**RE: Mesa Del Sol Neighborhood - Montage Units 3 & 4  
Drainage Report for Preliminary Plat Approval and Grading Permit  
Engineer's Stamp Date 6-6-2014 (File: R16D006)**

Based upon the information provided in your submittal received 6-6-14, the above referenced Drainage Report is approved for Preliminary Plat action by the DRB, but cannot be approved for Grading Permit until the following comments are addressed:

TYPICAL PERMANENT STORM POND DETAIL

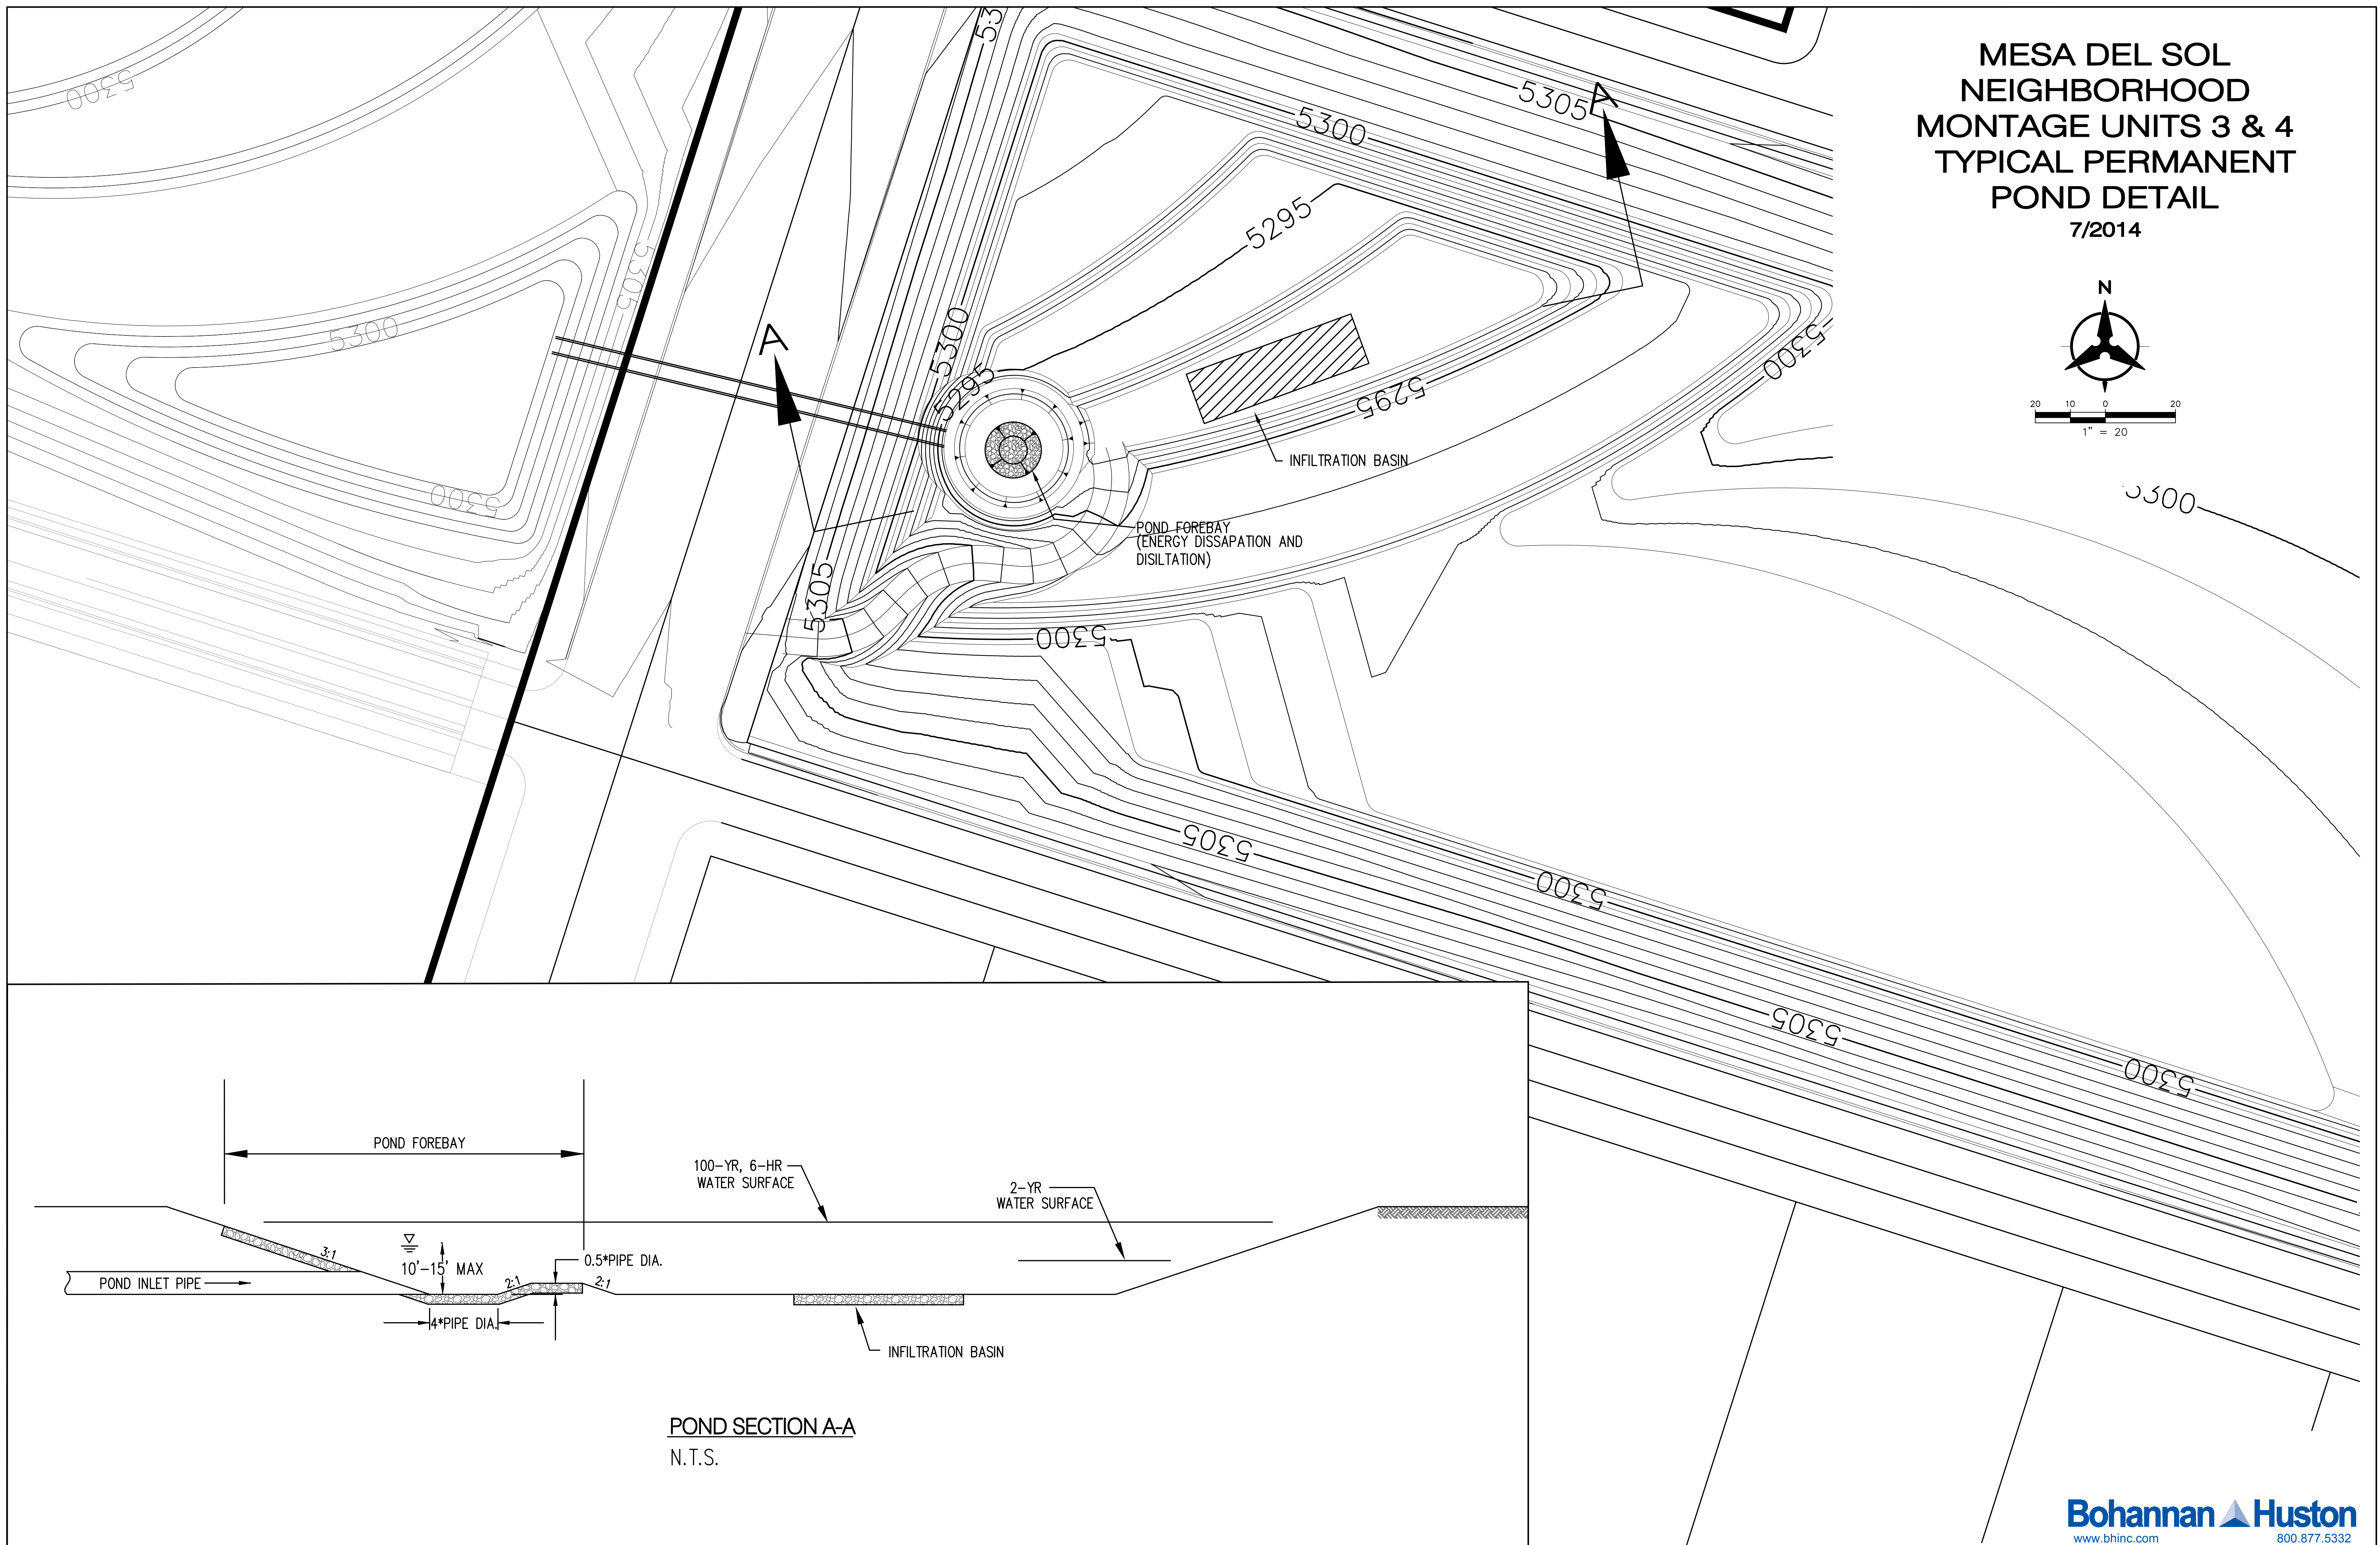
14. Pond detail sheet shows an outlet pipe for overflow. Are these outlet pipes already in place for ponds 2A, 2B, and 3? If so, please locate them on the Grading plan and show where the overflow discharges to. If not, take outlet pipe out of Pond detail sheet, or indicate for which ponds the outlet pipe detail applies.

EXHIBIT 9
GRADING PLAN

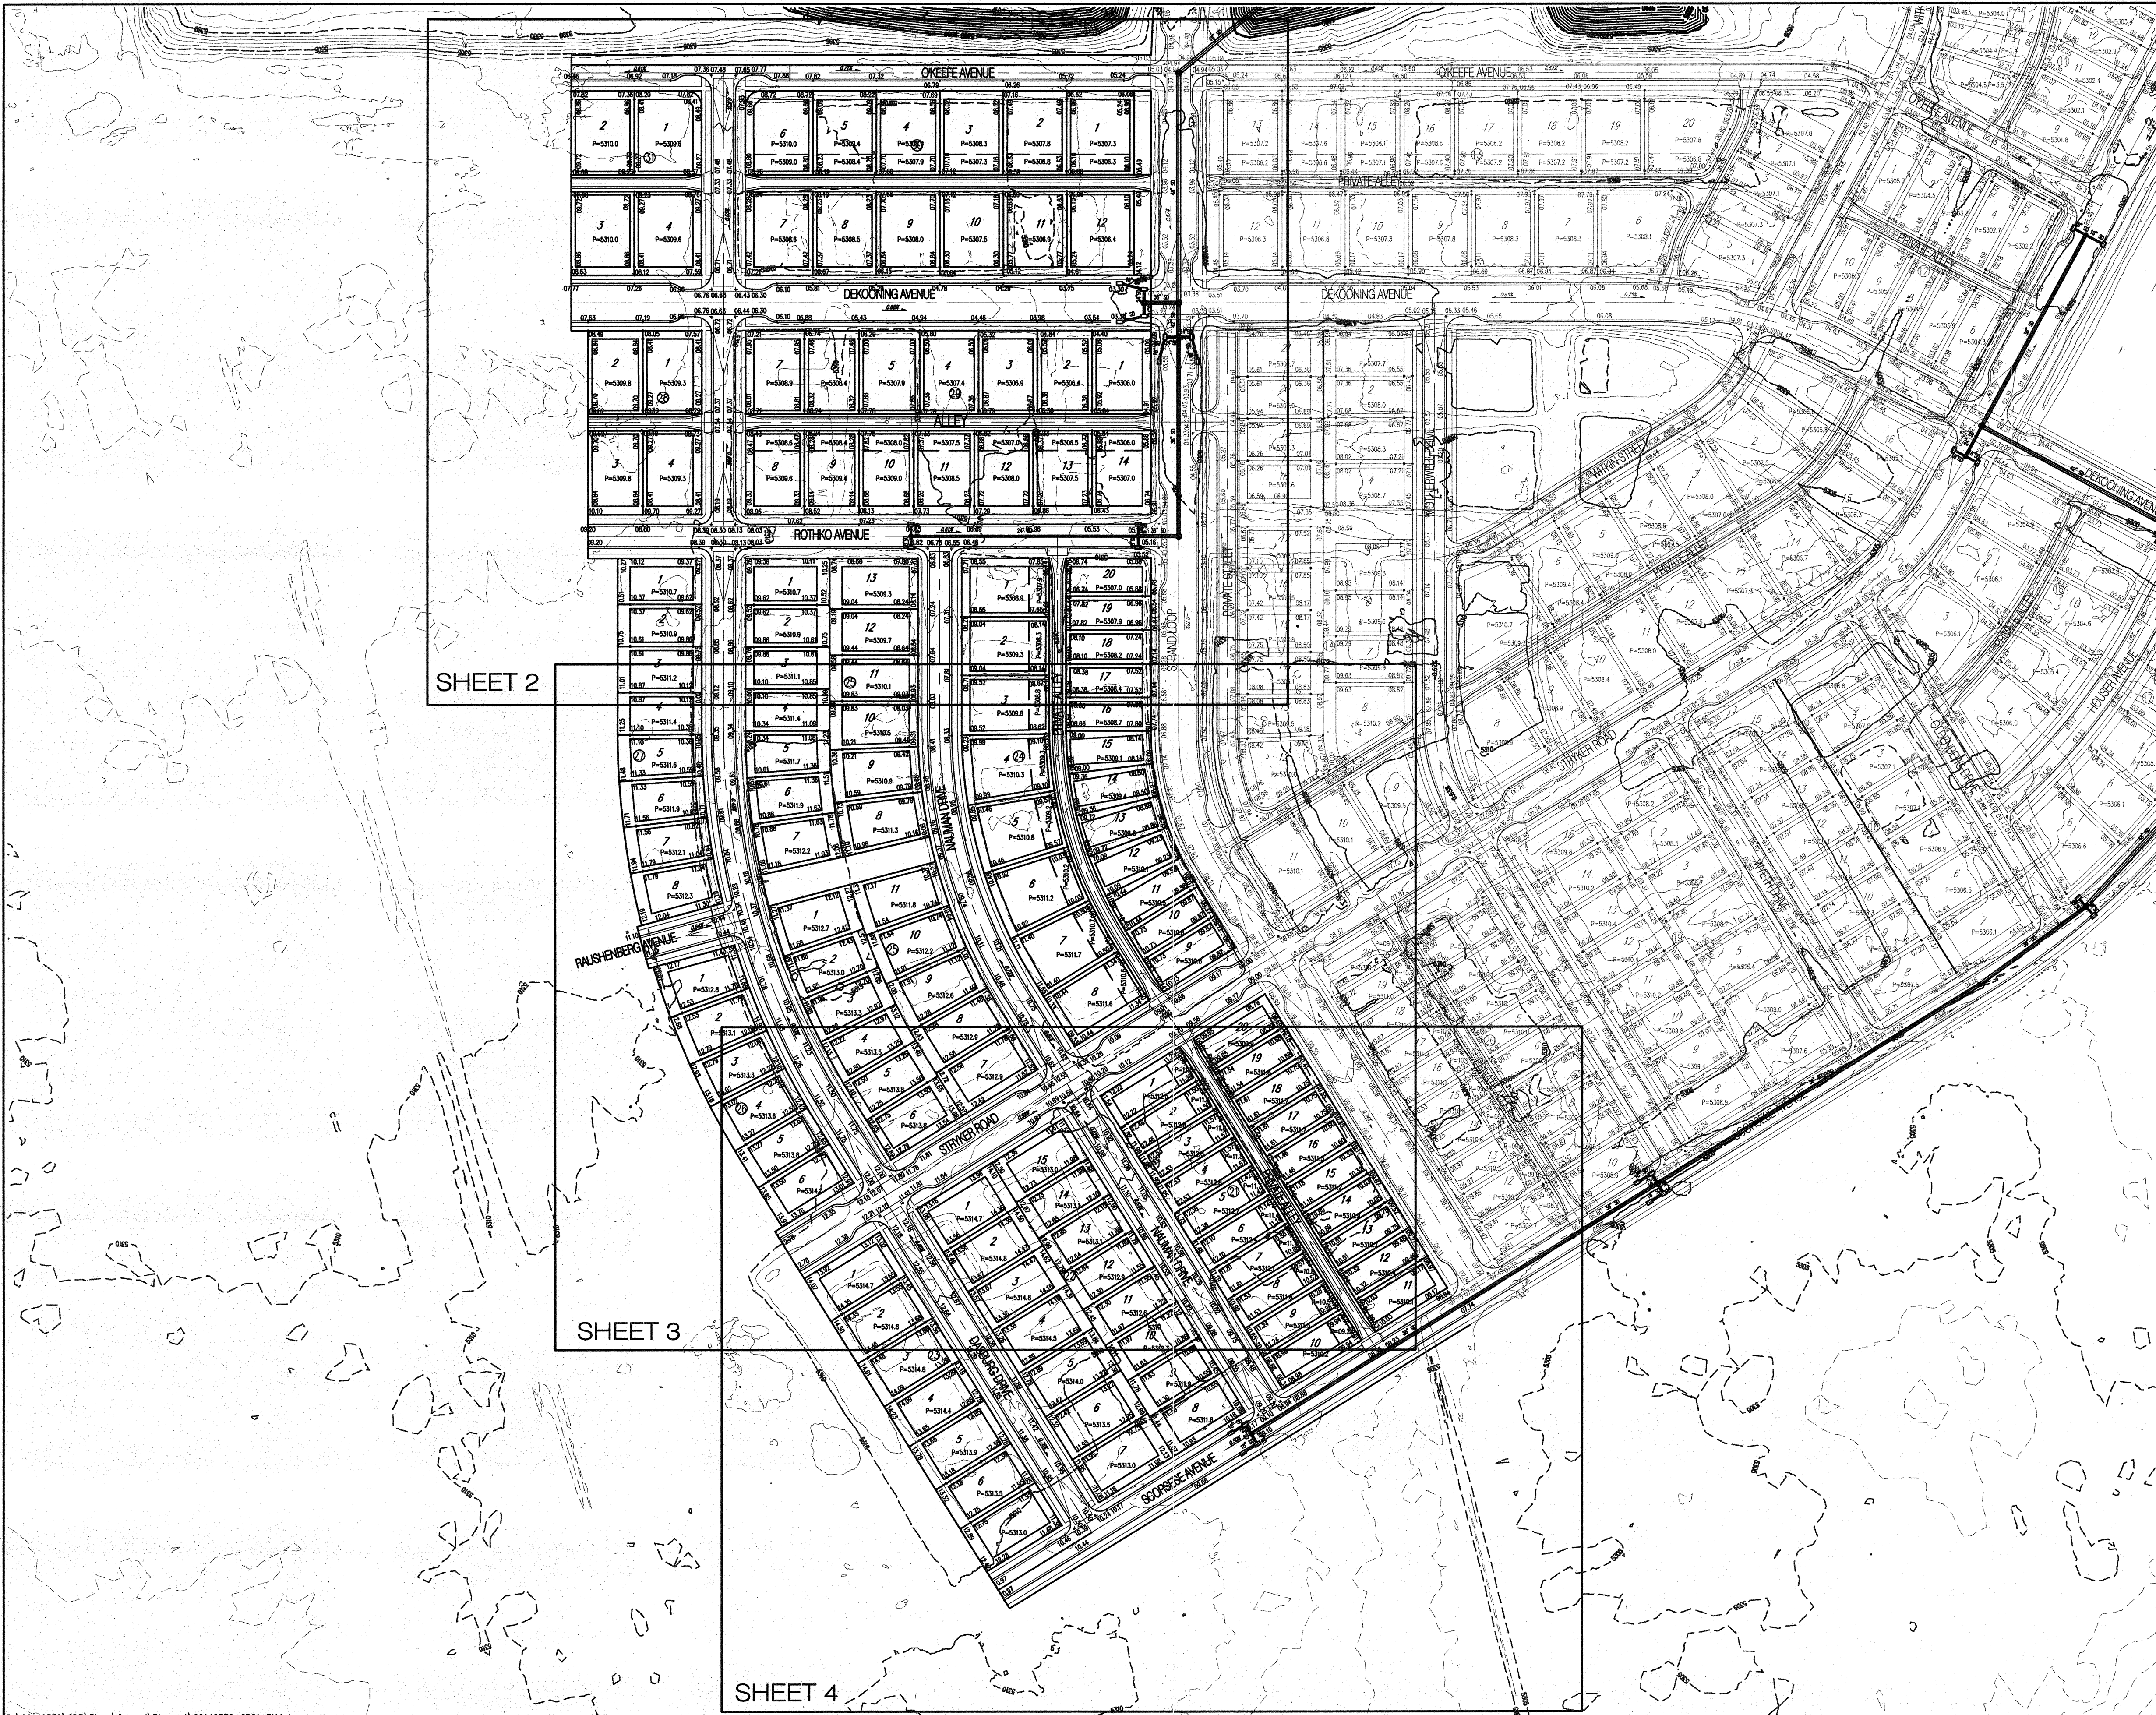
5. Show grading for all ponds used or modified in this project.
6. If Inlets 5, 6, 11 & 12 work in combination in a sump condition, then show what inlets will be built to support the interim condition, and show calculations for interim condition. Will a curb be needed for the interim condition?

10. Spot elevations on Lots 10 and 11 (south side) on SW corner of Strand and Stryker need to be verified.
11. Inlet #18 should be changed to IN18 (rather than IN15) on Storm Drain plan.

12. Verify spot elev. on east side of Lot 3 on SE corner of Stryker and Oldenburg.
13. How is open area north of Witkin Street to be graded?
